DRB Application No.: 08DRB-70379

Project Name: PEREA ACRES

DRB Comments

RE: Tracts D-1A & D-1-B, Perea Acres

SKETCH PLAT OF
TRACTS D-1-A & D-1-B
PEREA ACRES

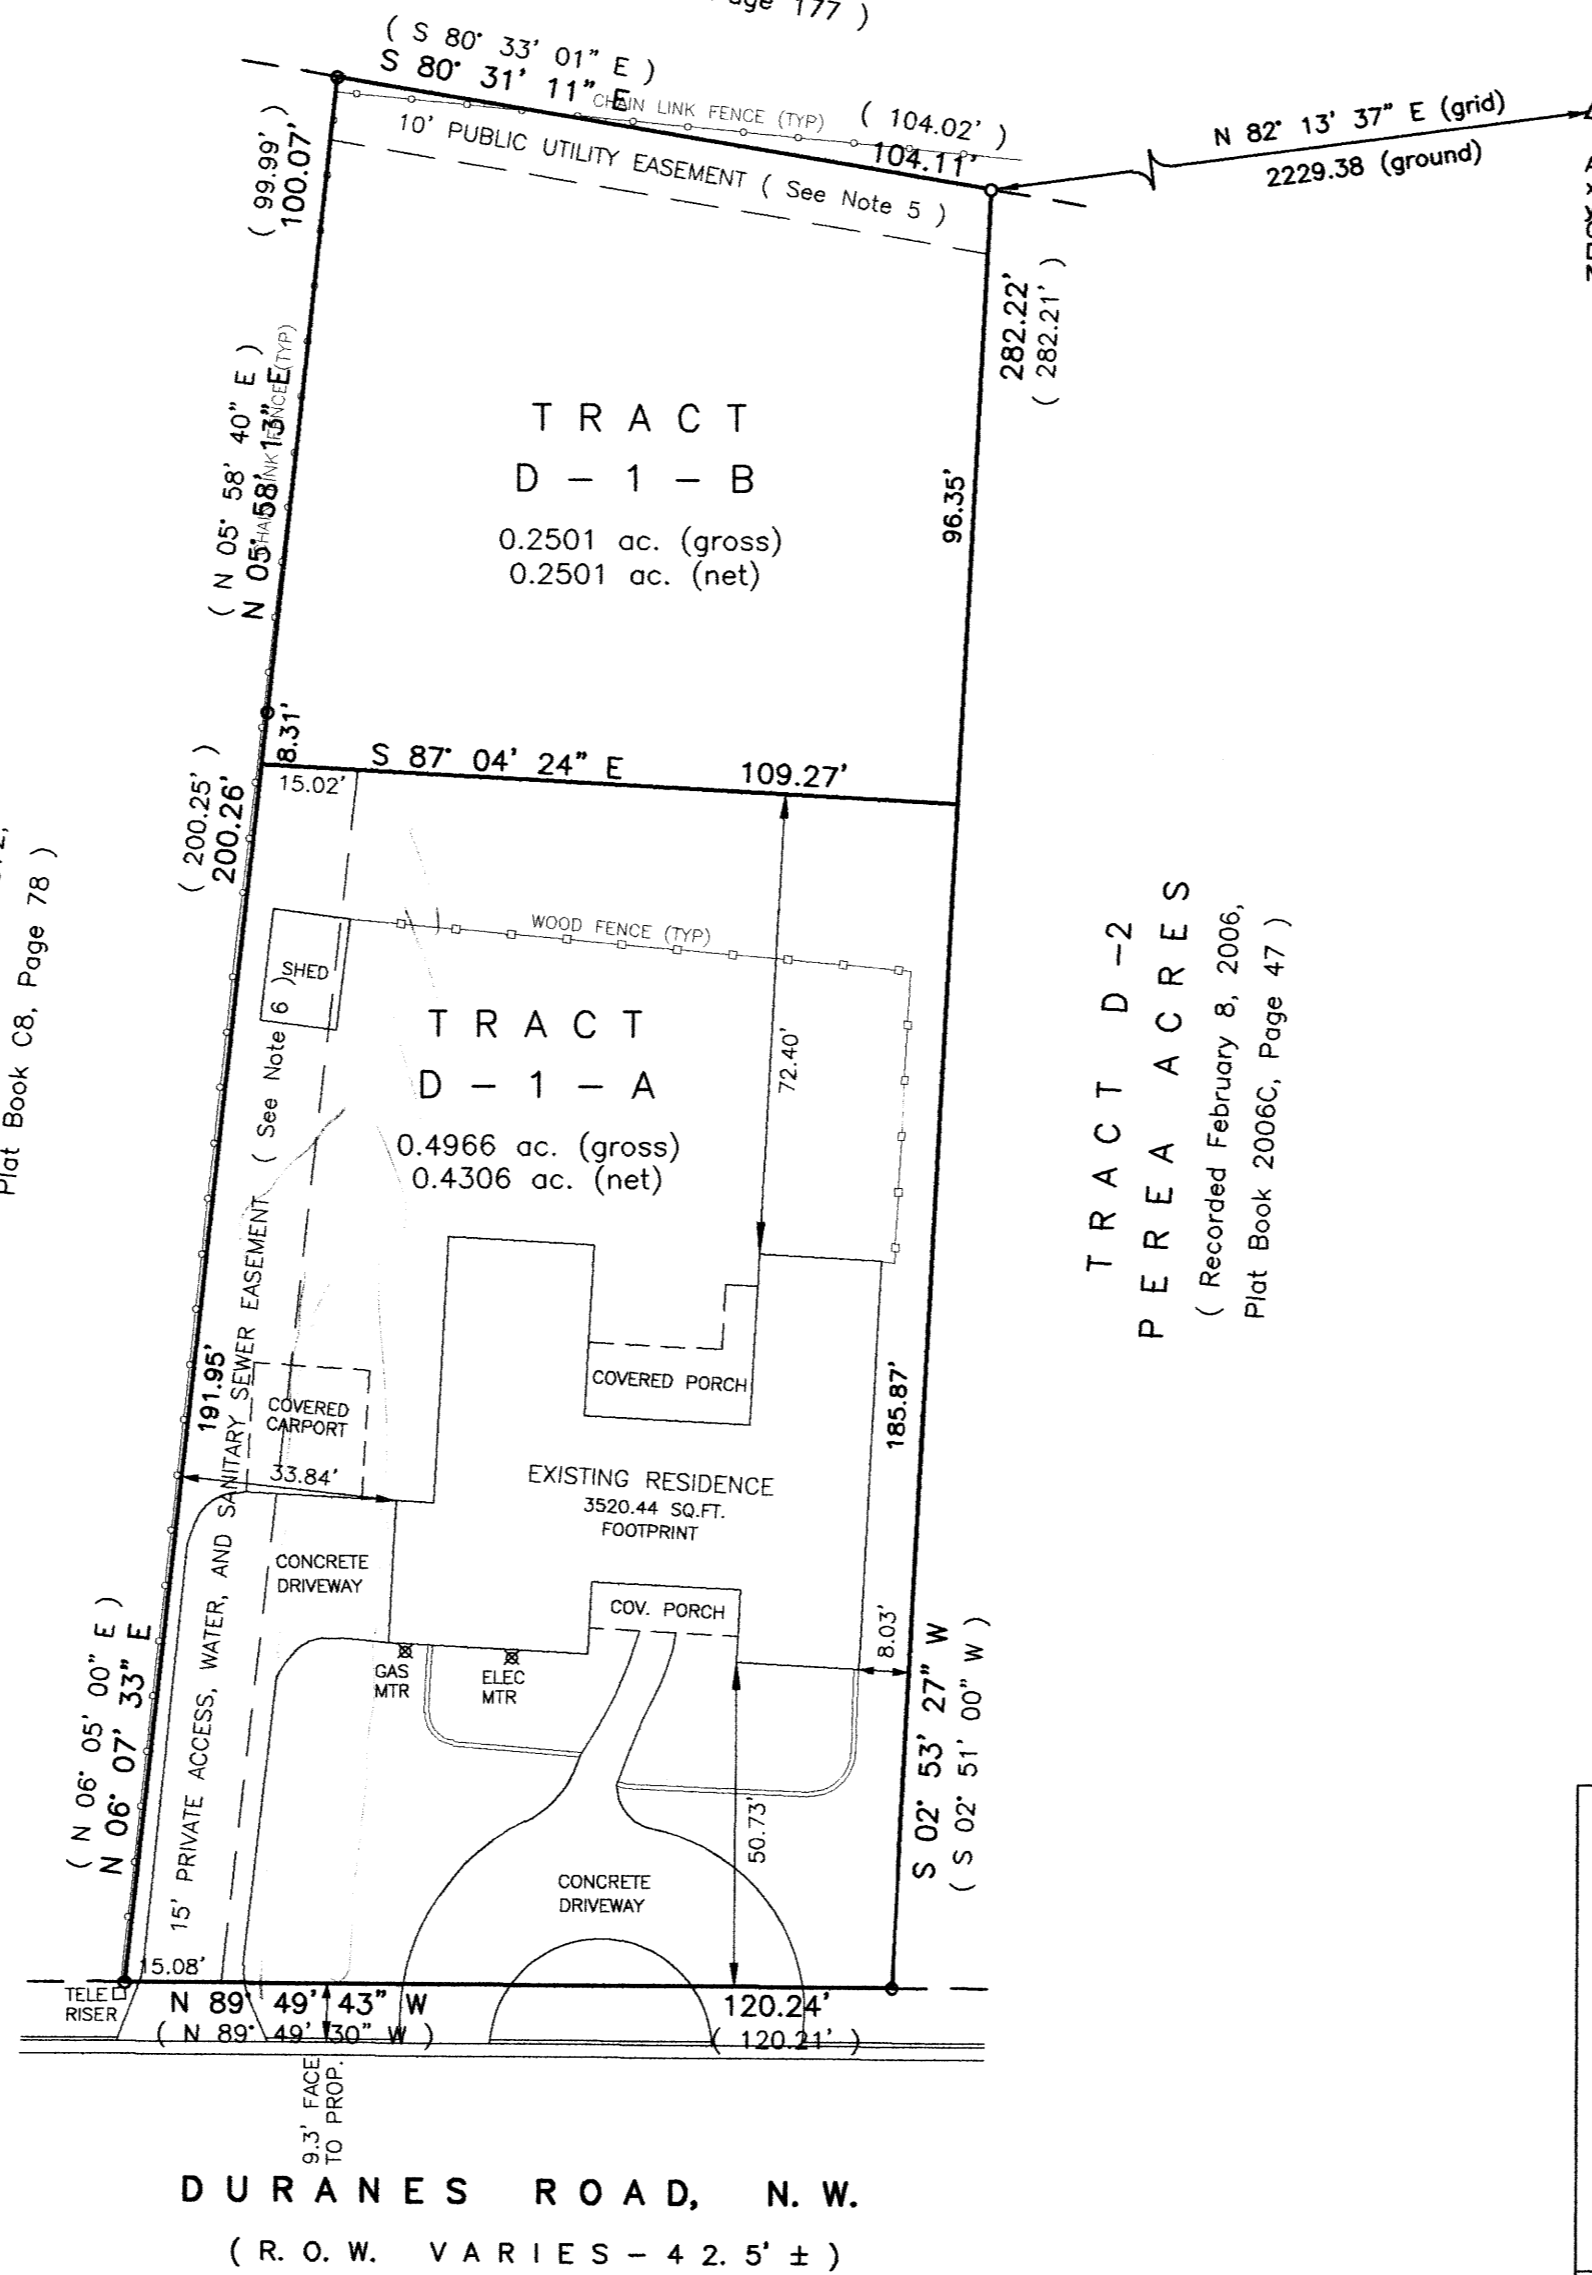
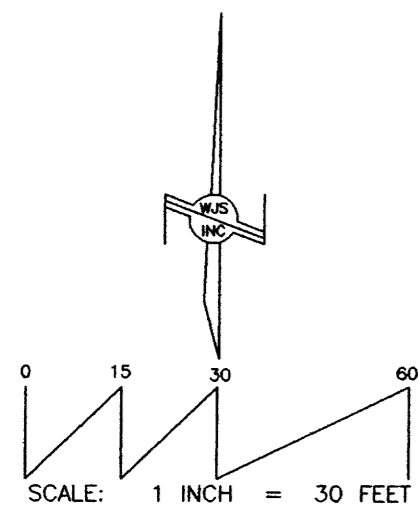
The minimum Lot size for the existing RA-2 zone is 10,890 sq ft – the new 'rear' would need to be around 100 feet deep. A minimum 15 Access and Private Utility Easement would have to be provided over the 'front' lot.
